KITITAS COUNTY

MEMORANDUM

TO: All Staff
FROM: Public Works Planning Review Team
DATE: December 8, 2020
SUBJECT: CB-20-00013 Balconi
Tax Parcels: 795334 & 805334

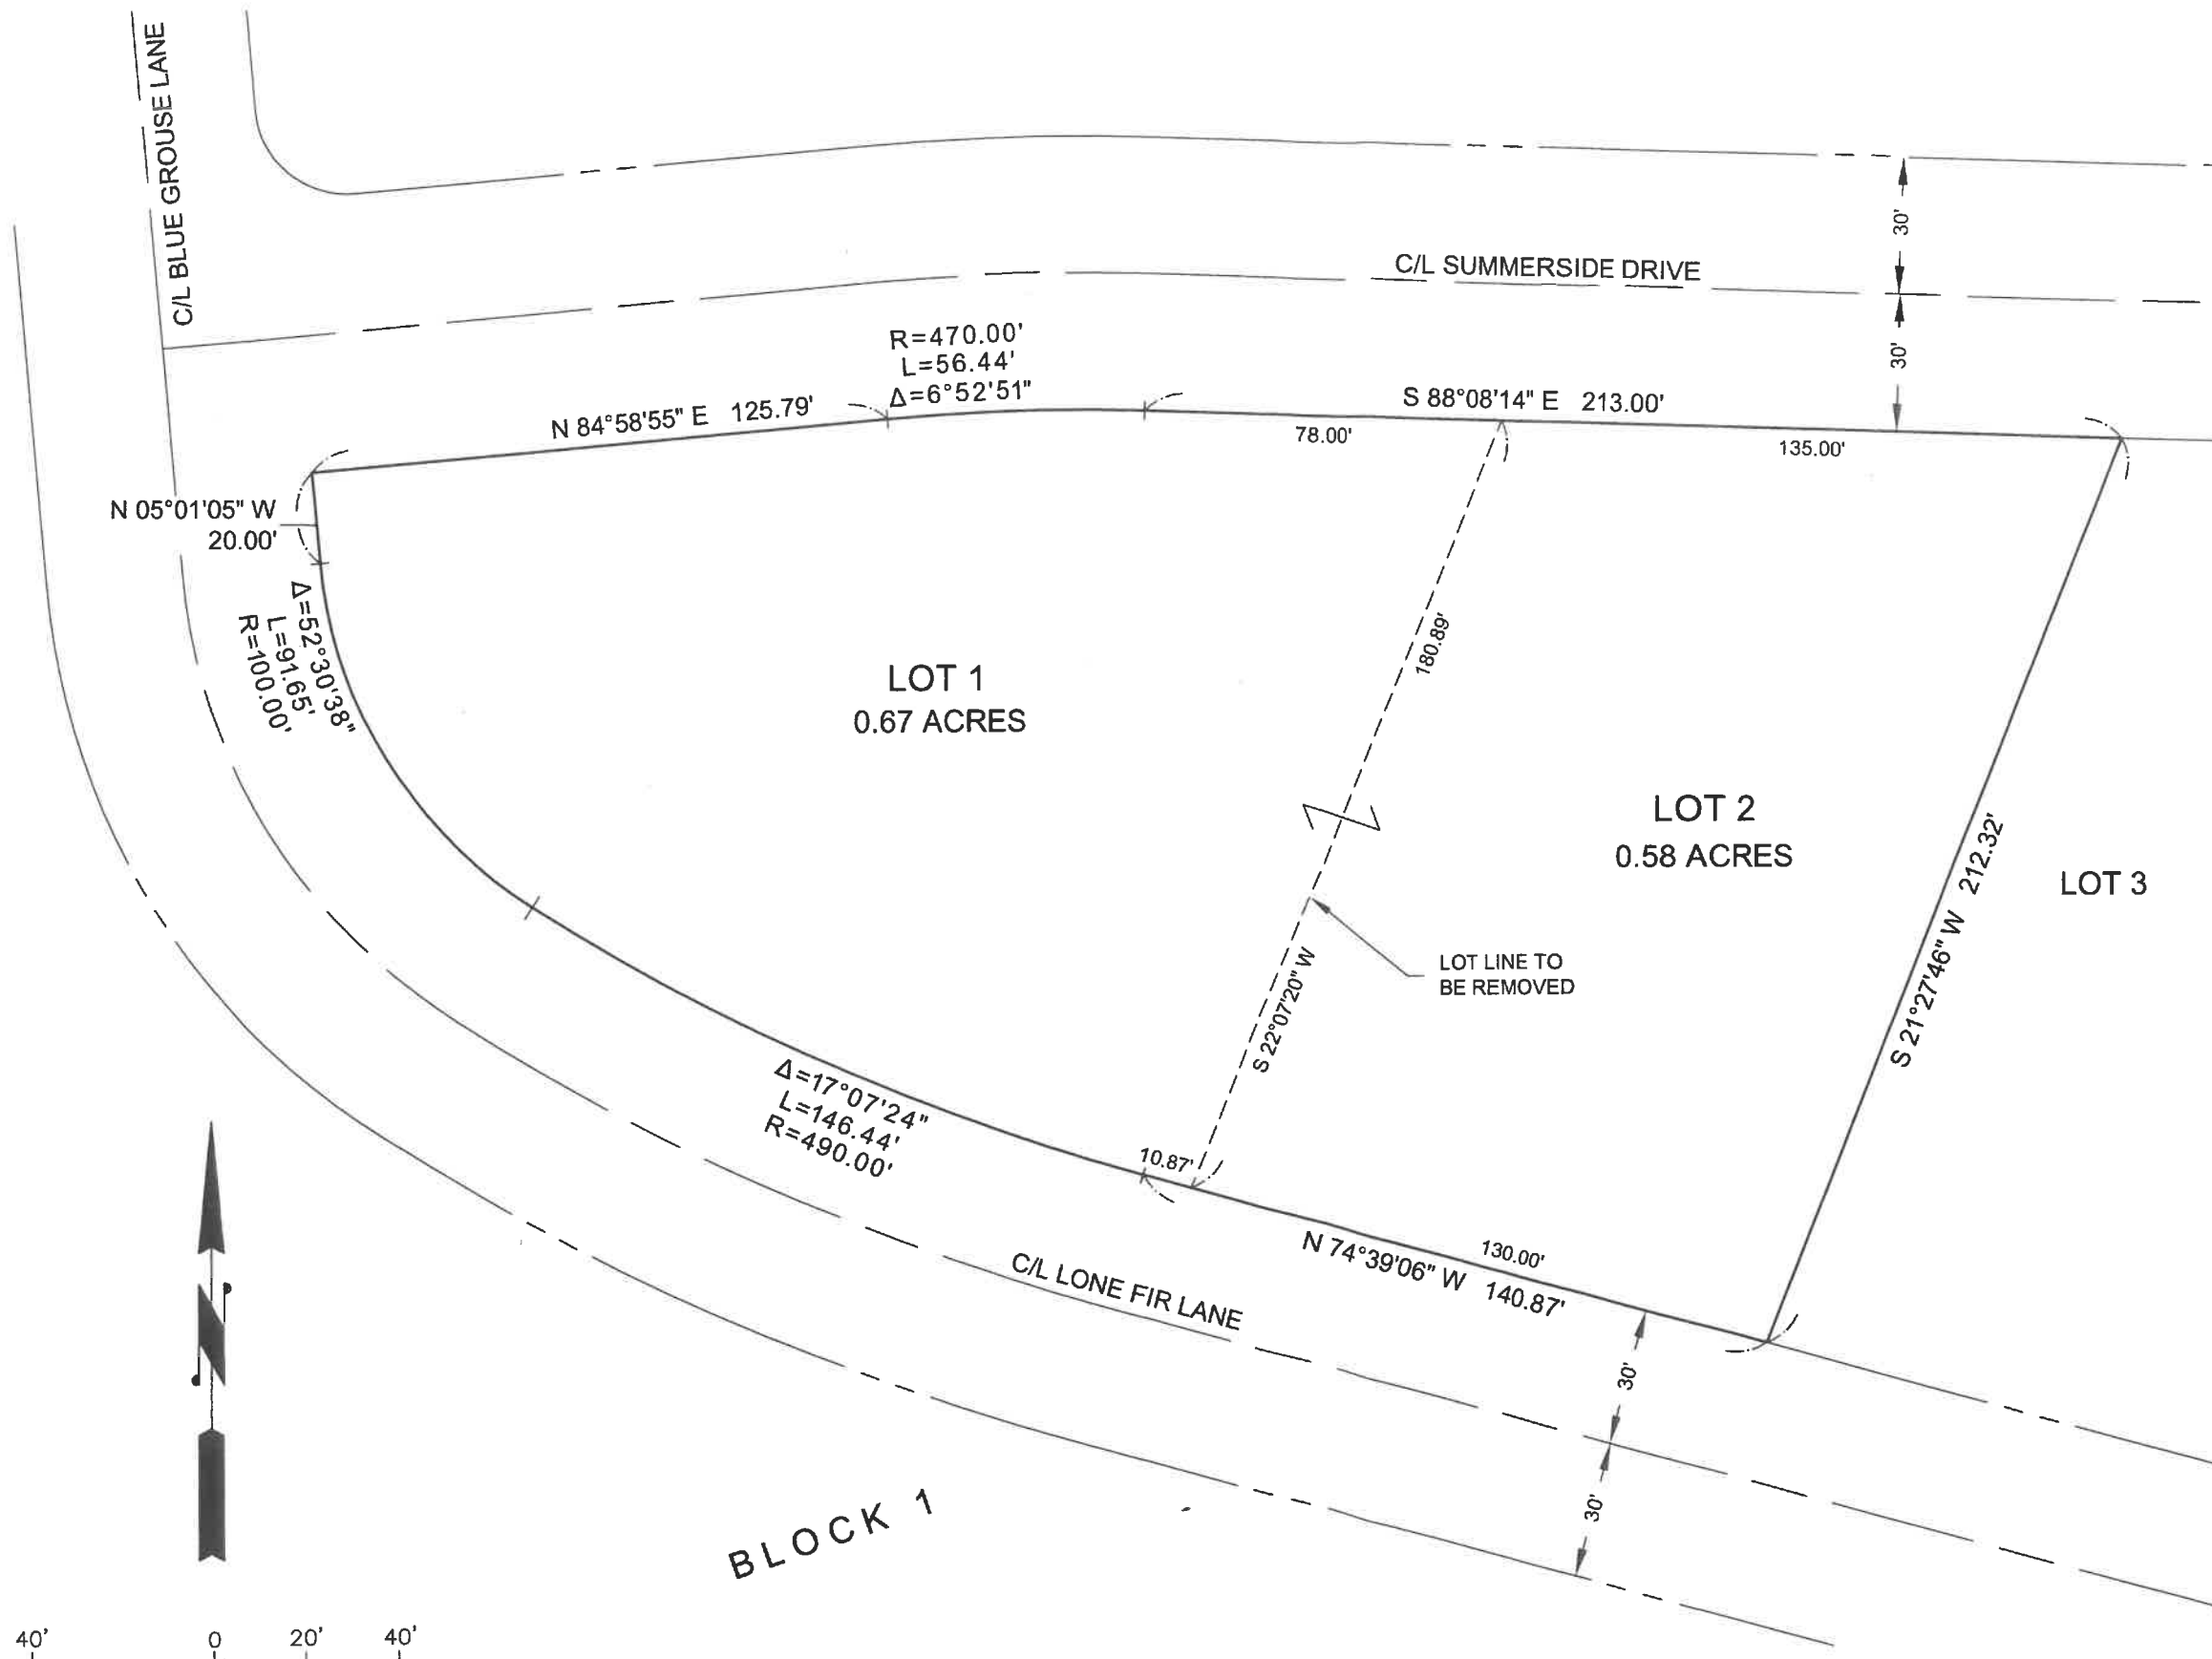
- a) Applicant has a current access permit (AC-20-00125) showing the new driveway entering from parcel 805334. This will change the 71 Lone Fir Ln address due to the driveway location changing. Applicant would need to apply for a new address and the 71 Lone Fir Ln would be removed from the addressing system.
- b) Any future development of combined parcels shall require and access permit through Public Works. See Kittitas County Road Standards.
- c) Please note that the exhibit drawing included as part of the application does not show the 20' radius at the intersection of Summerside Drive and Blue Grouse Lane. This is minor and is not significant enough to change lot areas. It is only being mentioned as not to change this aspect within the county GIS system.
